PLAN REVIEW SHEET

Petition #: RZP 2022-179

Address: Pressley Rd.

Request: MUDD

TECHNICAL DATA SHEET

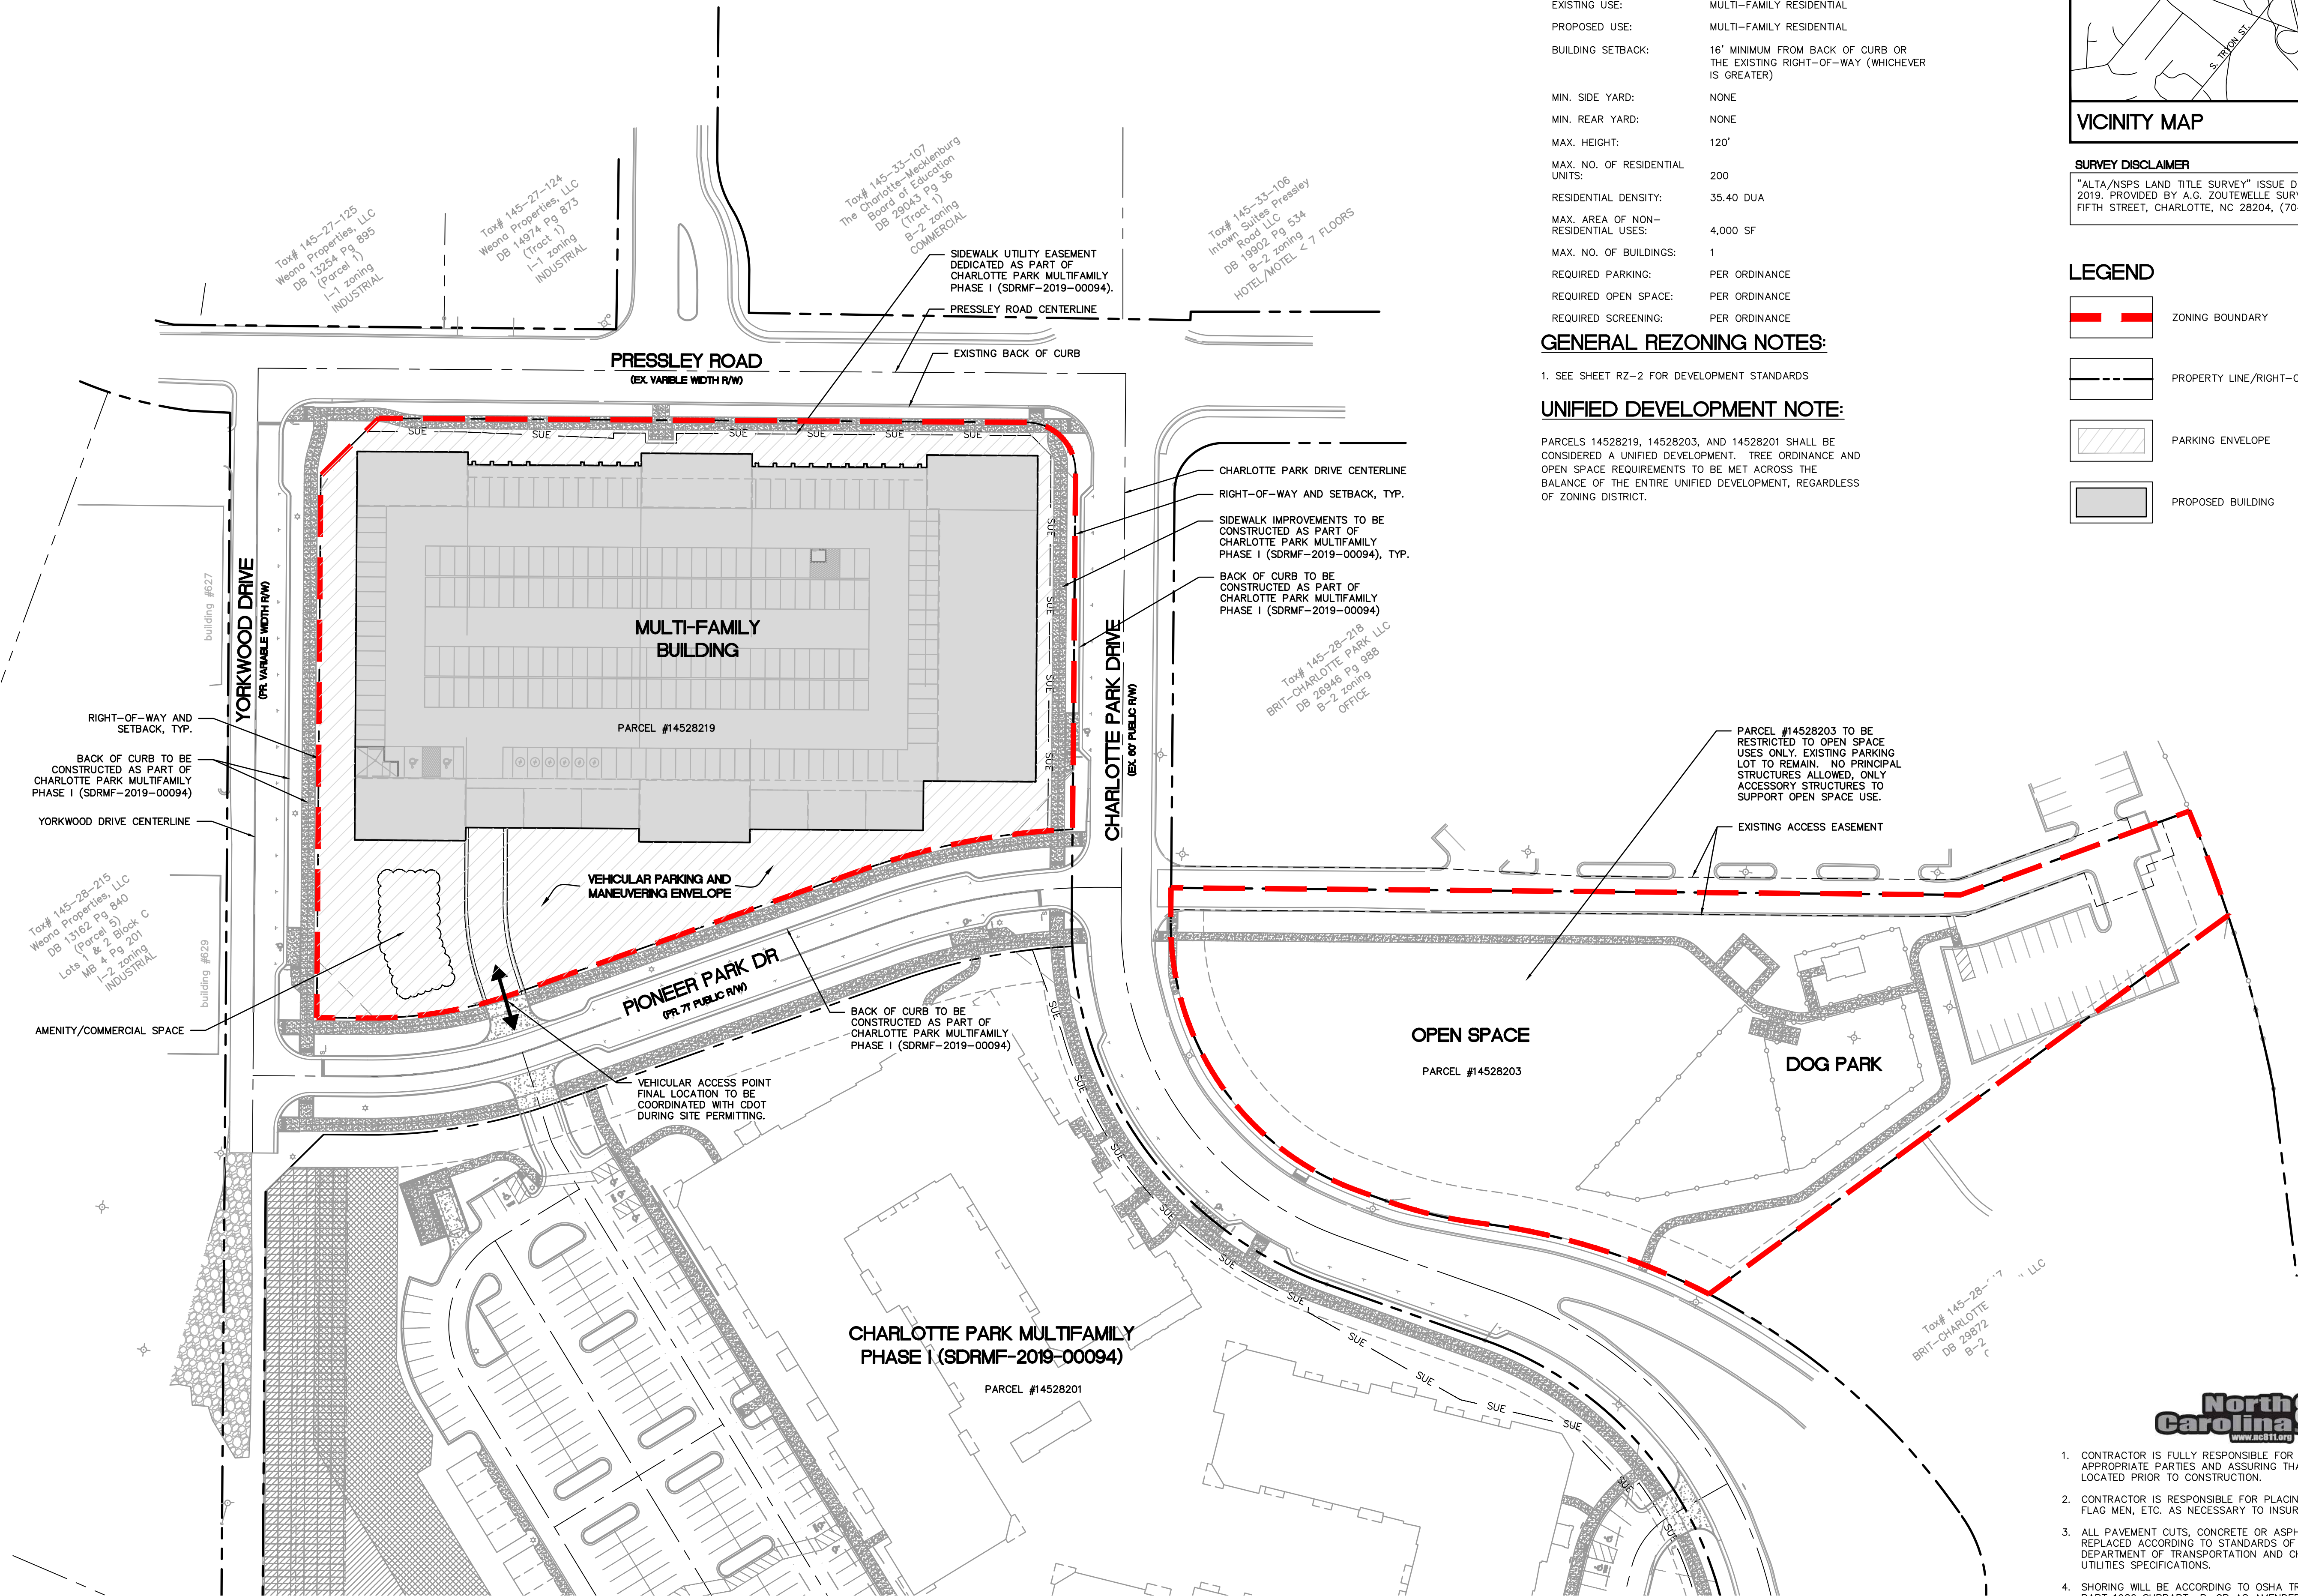
The site is located along CATS local bus route #12 on Pressley Road. CATS requests the construction of ADA compliant bus standard detail 60.05B on Pressley Road. The final location will be coordinated with the developer during the Land Development plan review process.
